Application number: 2025/92882	
What is the application for?:	Erection of 75 dwellings with associated parking, infrastructure, hard and soft
Address of the site or building:	Cellars Clough Mill, Manchester Road, Marsden, Huddersfield, HD7 6LY
Postcode:	LS10 1FB

Type of comment: An objection	
Do you wish your comments to be published on the website anonymously?	Yes

proposed plan 1:250 showing new access from towpath through to site entrance road & new (re-used stone) steps up to existing footbridge

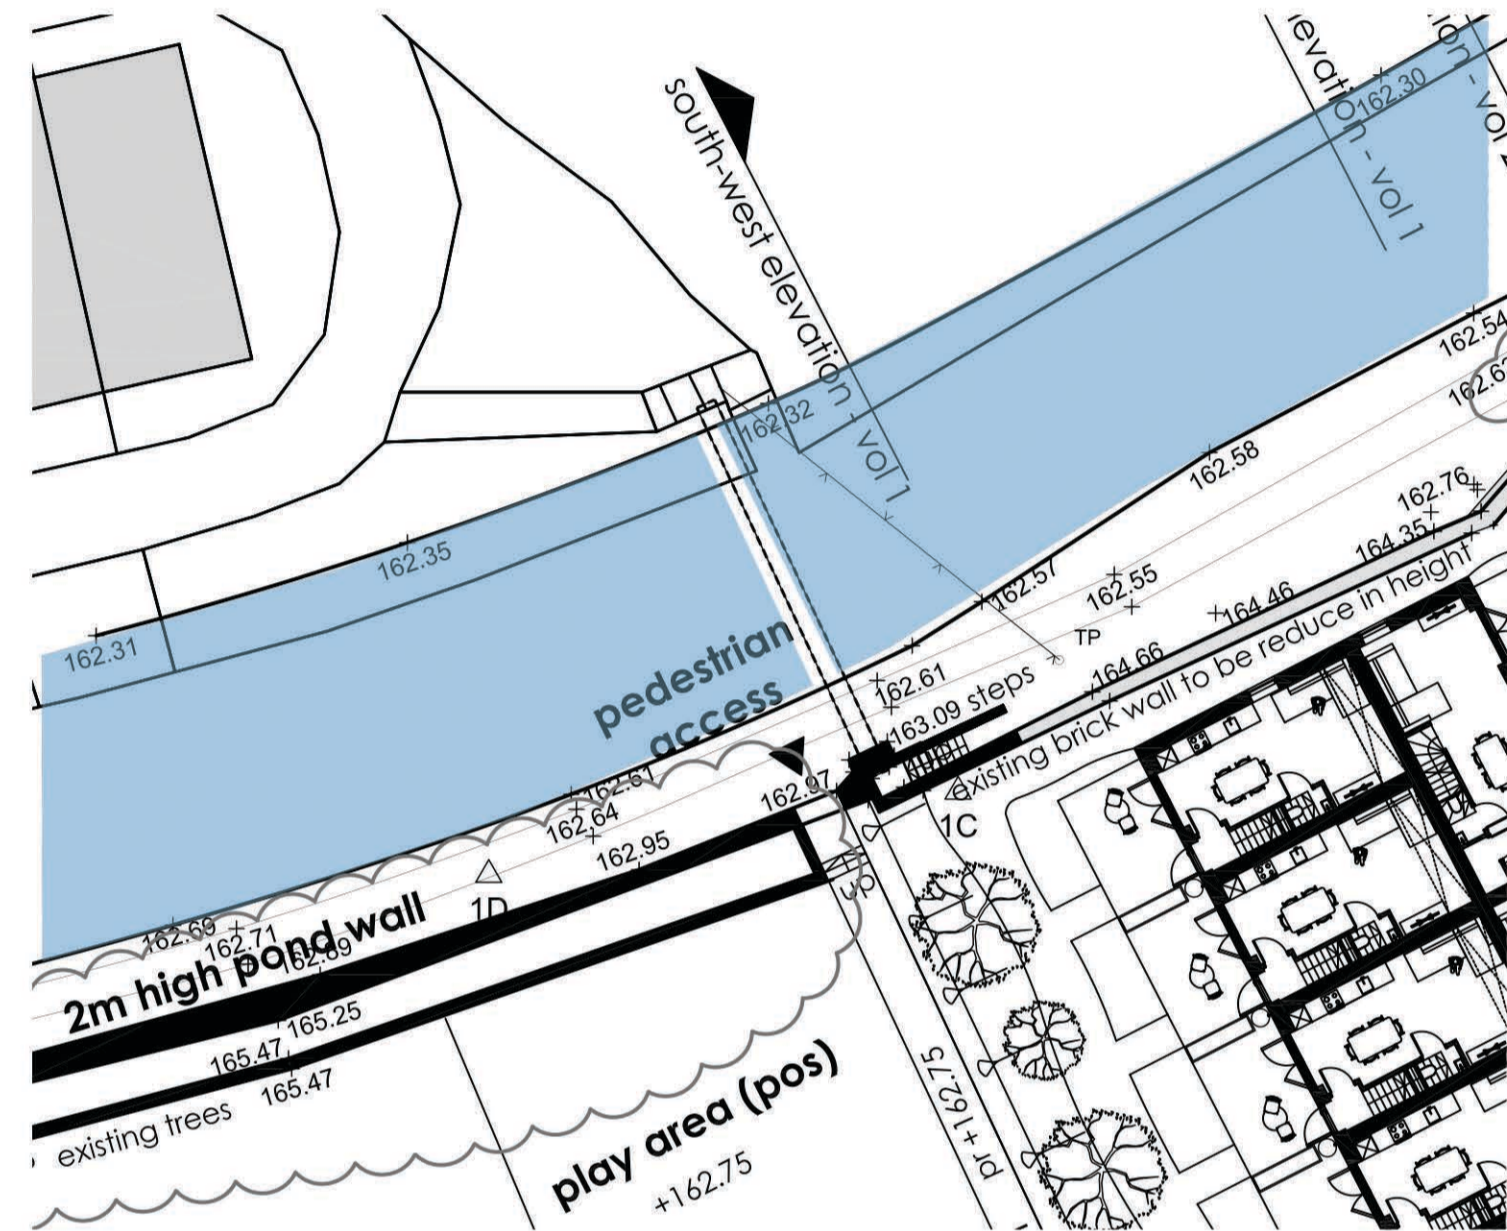
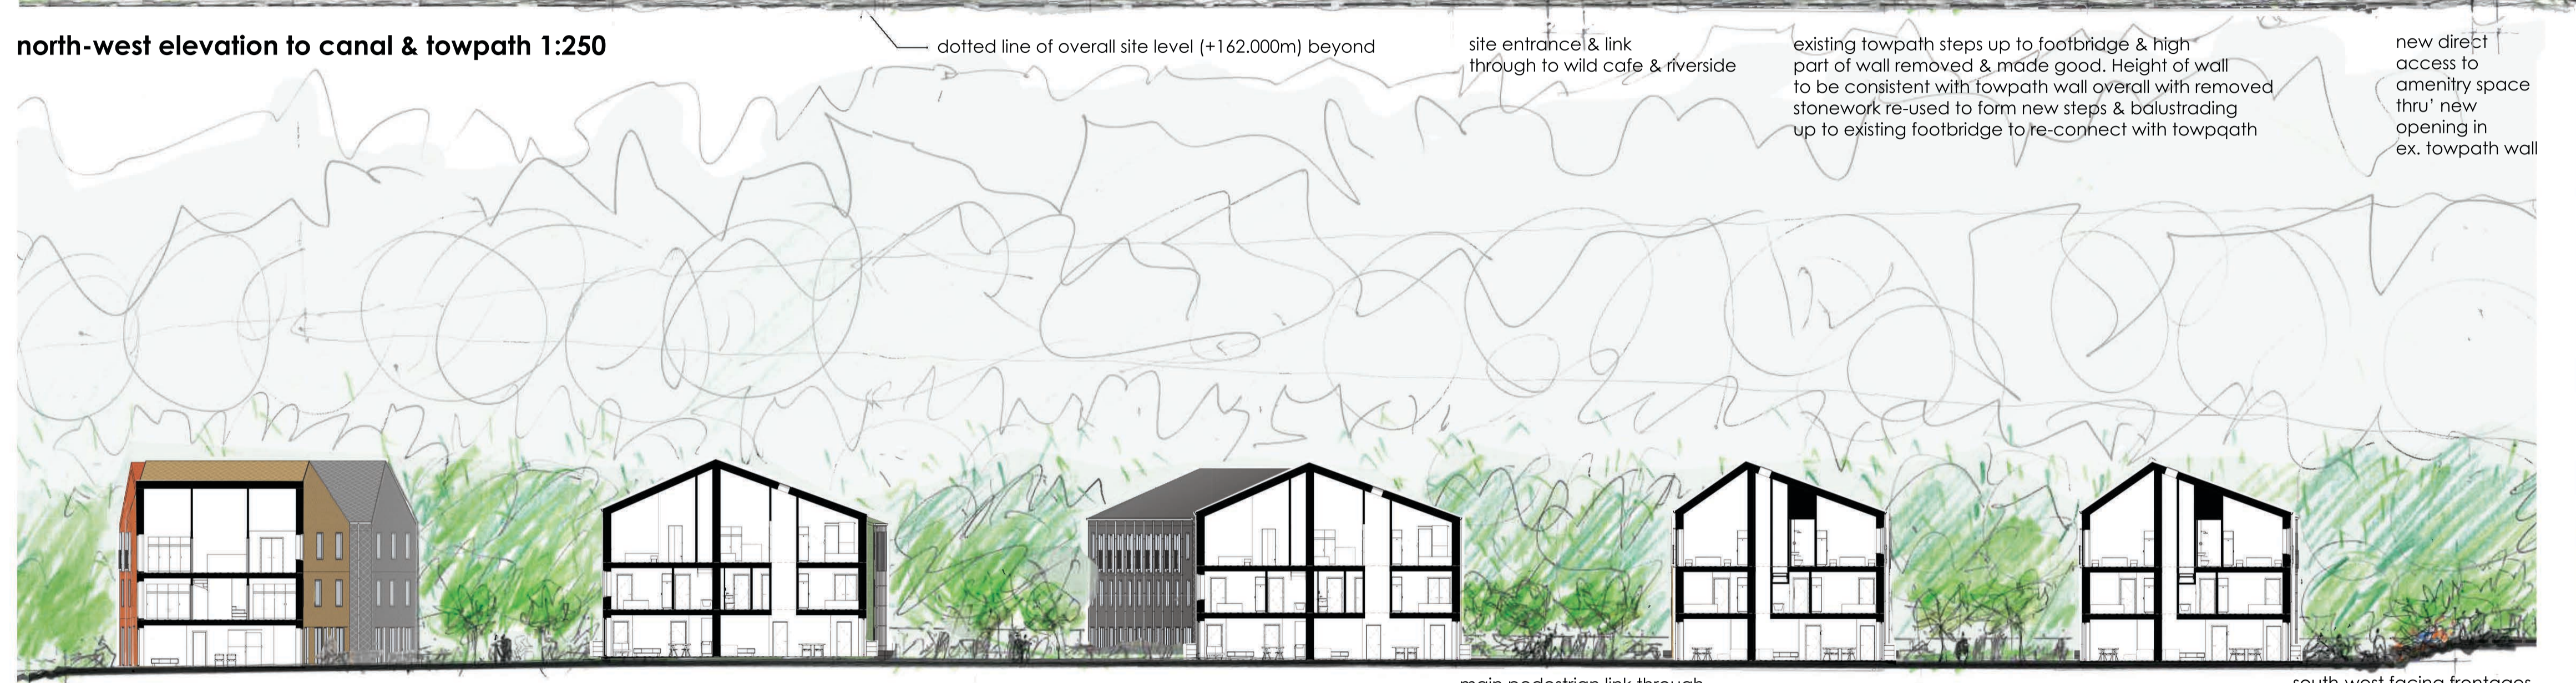
Safety concerns are also elevated due to the close proximity of the proposed new footpath which accesses the canal towpath (replacement for the bridge).

Instead of repairing or replacing the current bridge the proposed new footpath punches through the 2m wall that has previously been designated as flood defence.

The plans (PO24) state that the wall between the canal towpath and the development is to be lowered. Developers had previously been told they had to raise the current height of that wall due to safety concerns for users of the towpath.
